Re: Construction Seminars - 4927 Prospect Ave NE; Bldg Permit # 201691091
Request for Certificate of Occupancy- Transportation Development
Architect's Stamp dated 08-04-16 (H17D112)
Certification dated 10-13-16

Project Title: Construction Seminars

Re: Construction Seminars Renovations
7915 Prospect Ave NE
Traffic Circulation Layout
Architect's Stamp 08-04-16 (H17D104)

Re: Construction Seminars Renovations
4915 Prospect Ave NE
Traffic Circulation Layout
Architect's Stamp 07-20-16 (H17D104)
12

PROPOSED SITE PLAN - TRAFFIC CIRCULATION LAYOUT SUBMISSION

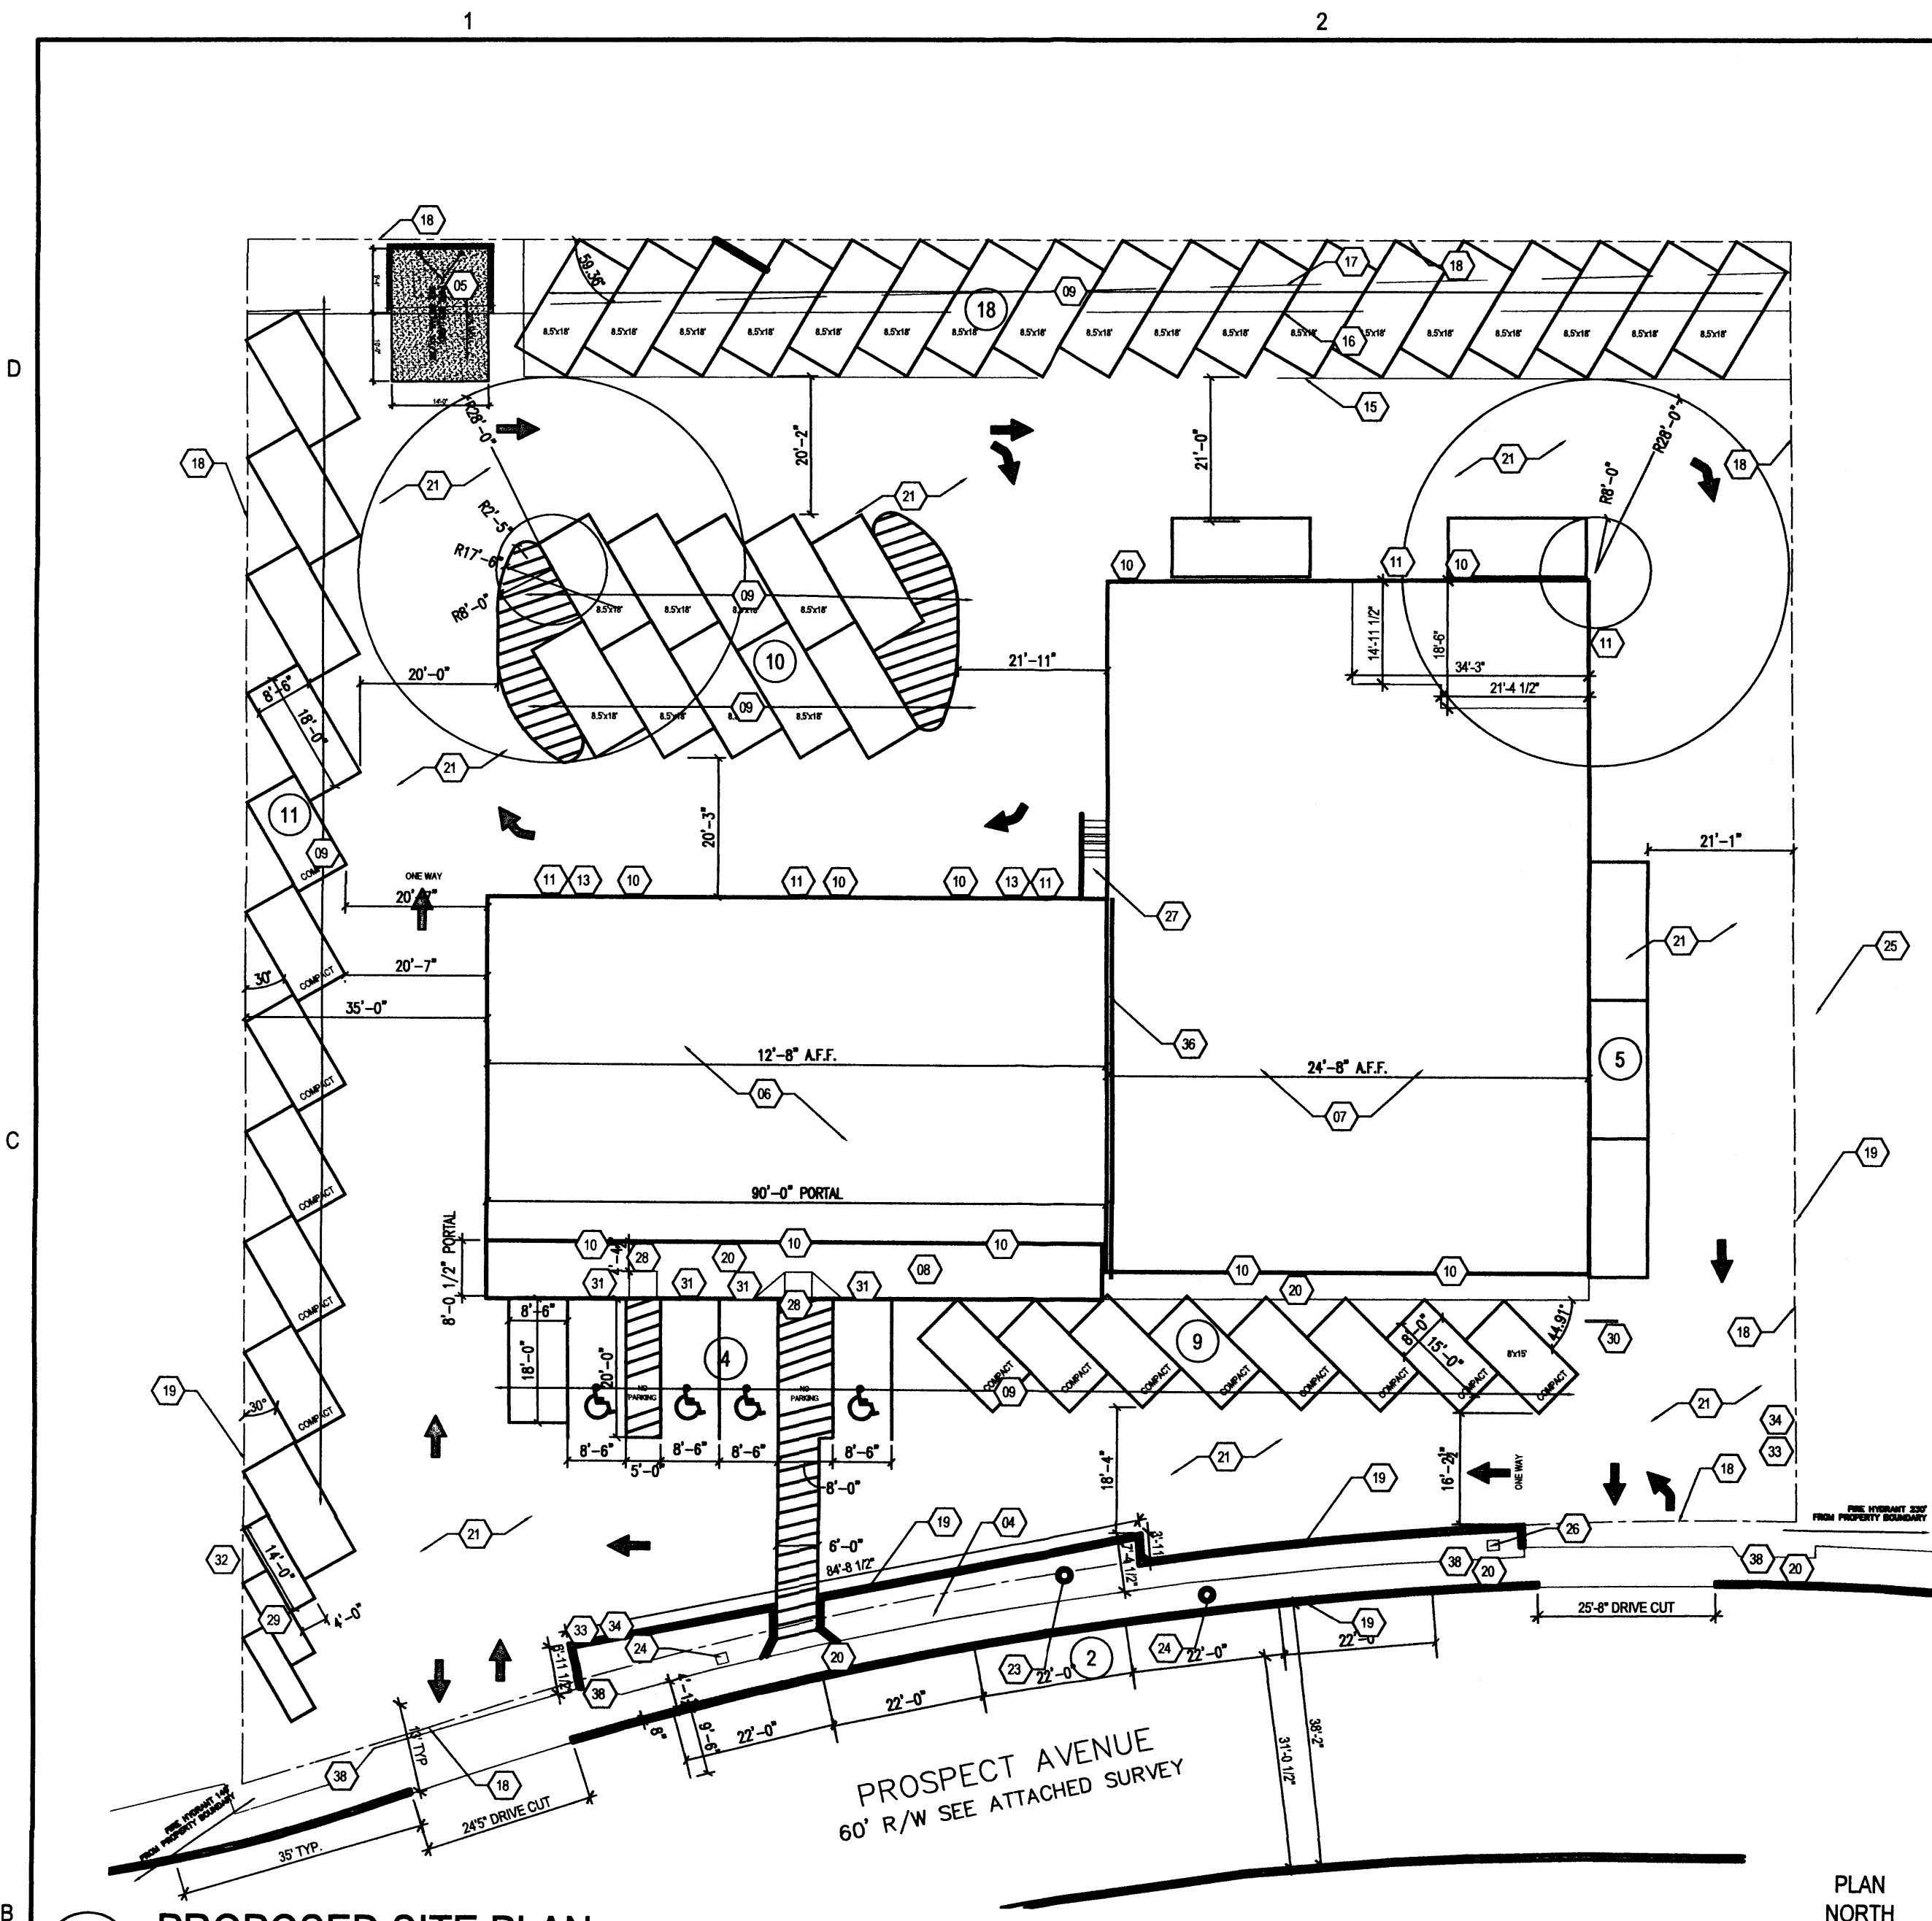
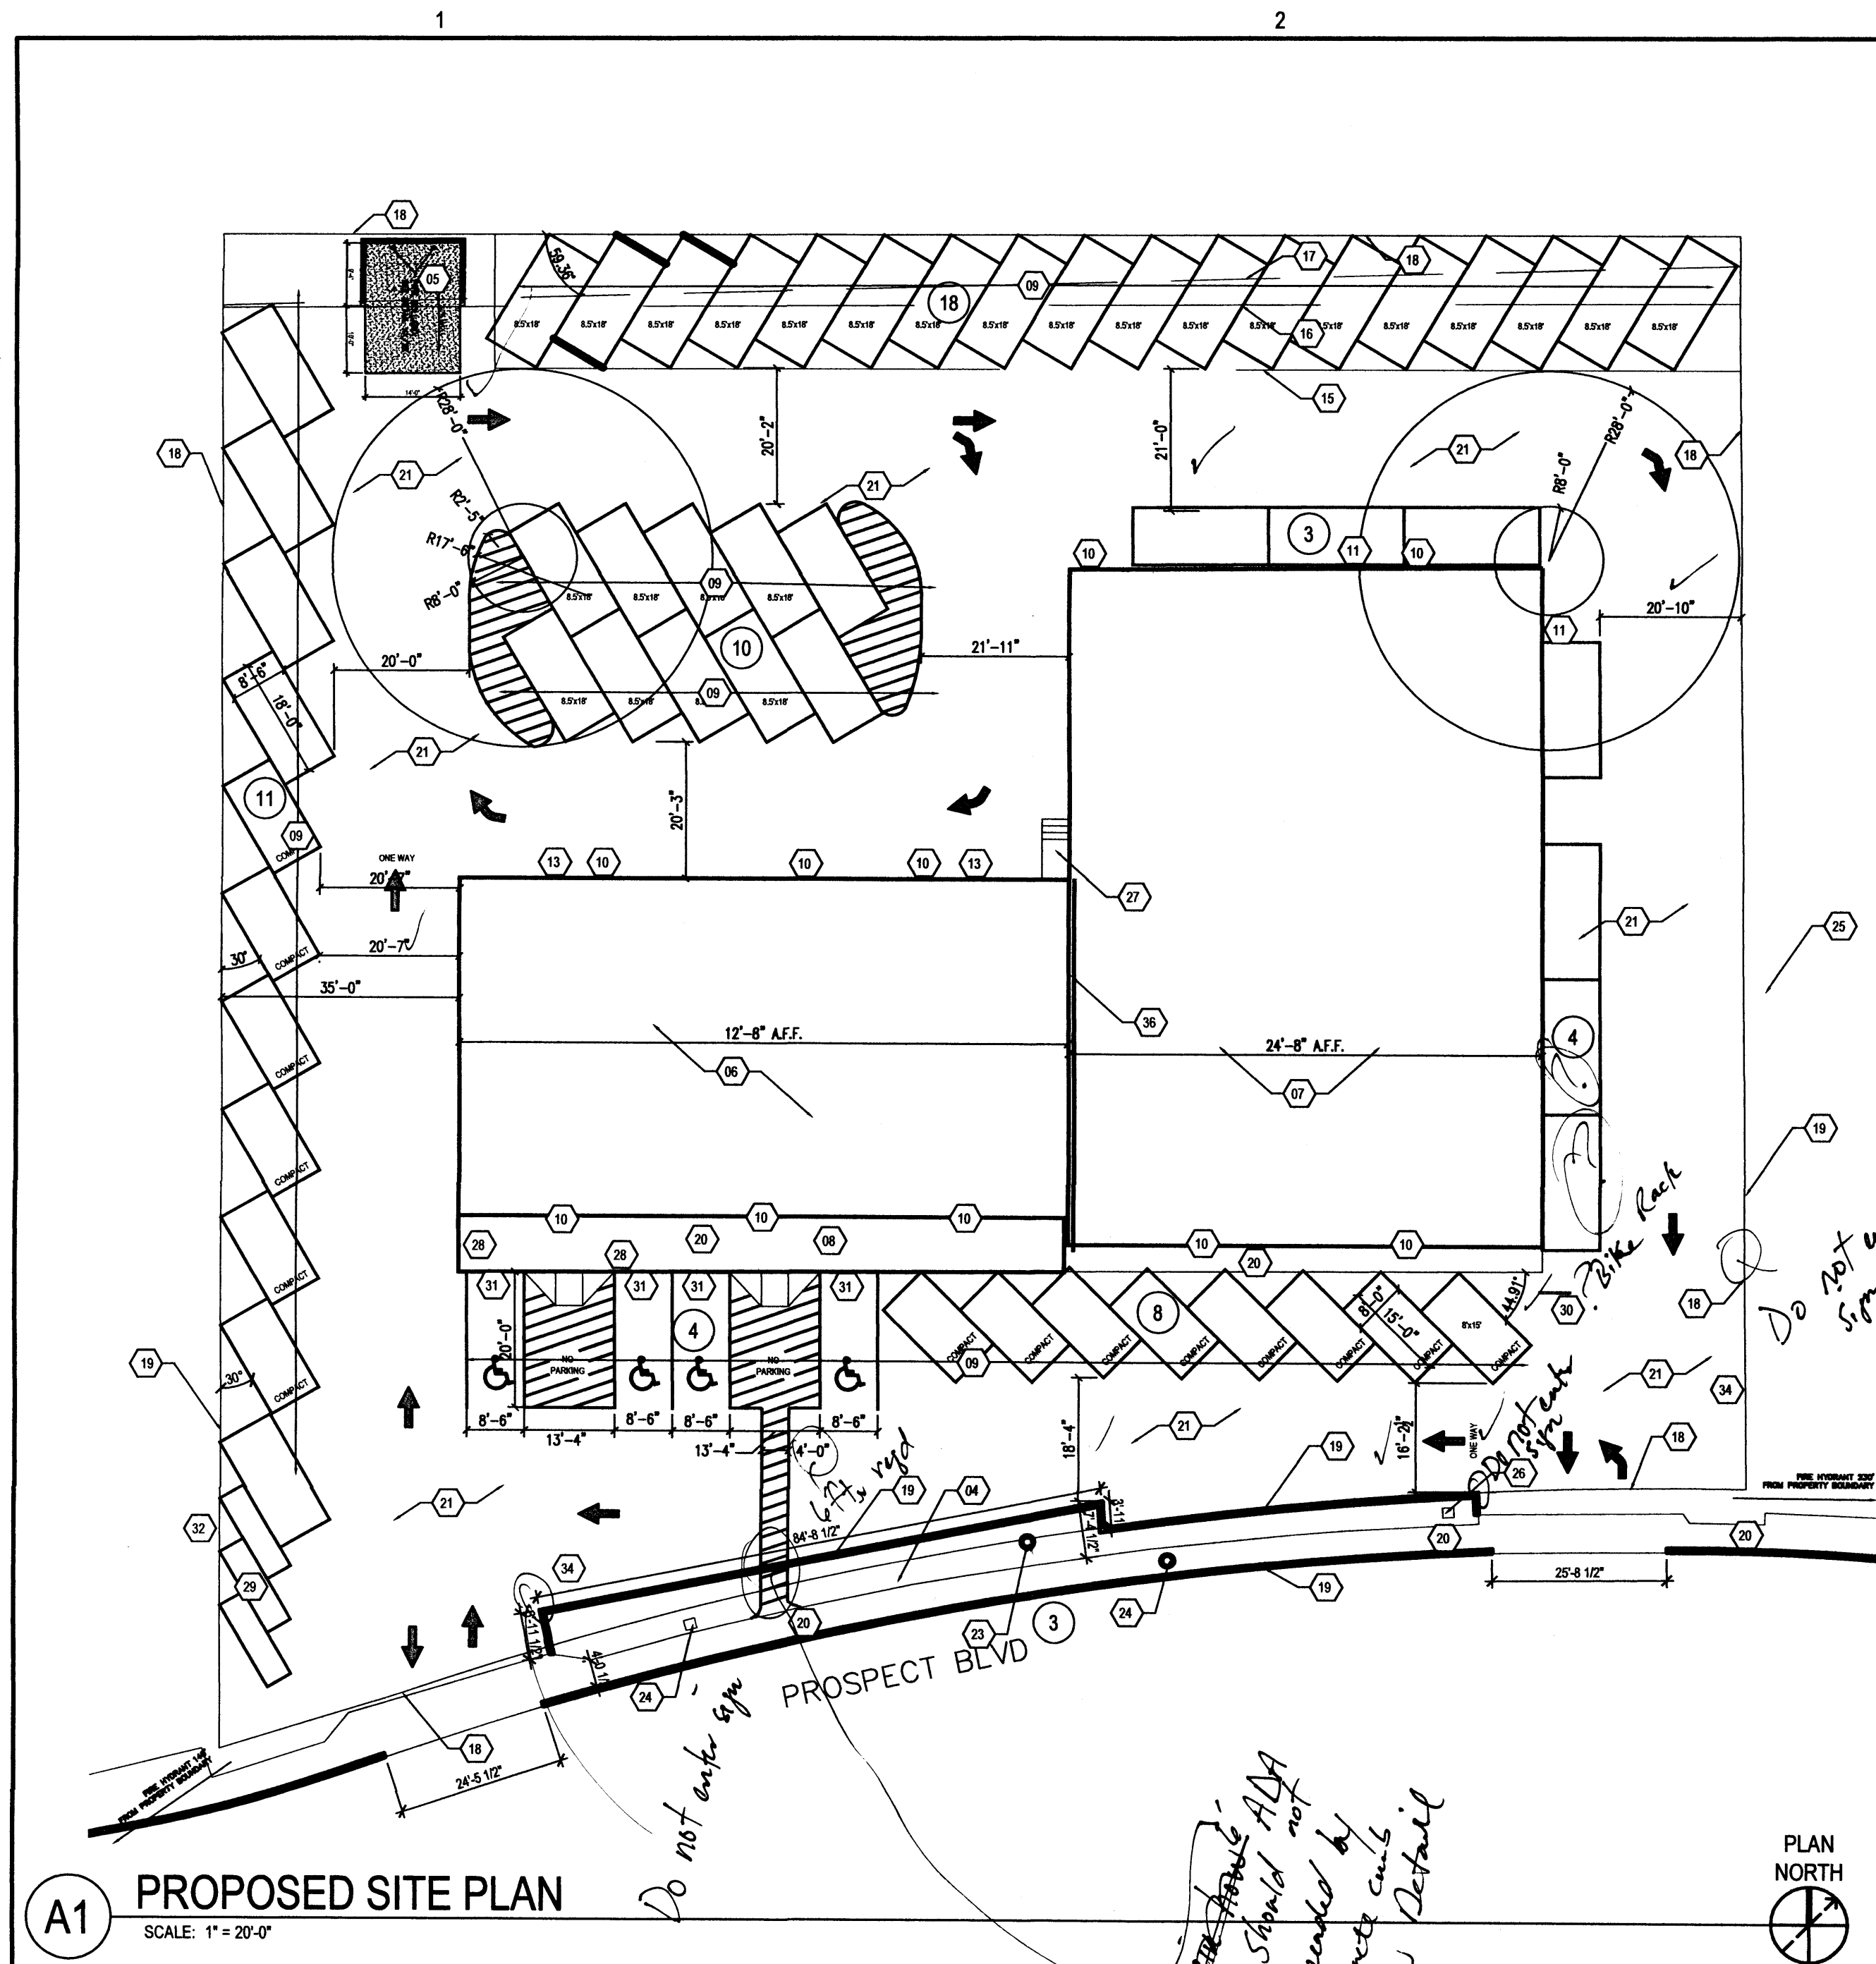
1. The 6' pedestrian access aisle called out on the approved TCL must be completed per plan.
2. The ADA access aisle route to the warehouse is not in compliance with ADA guidelines for slopes requirements. One HC parking space and access aisle will need to be relocated to allow proper ADA access to the building.
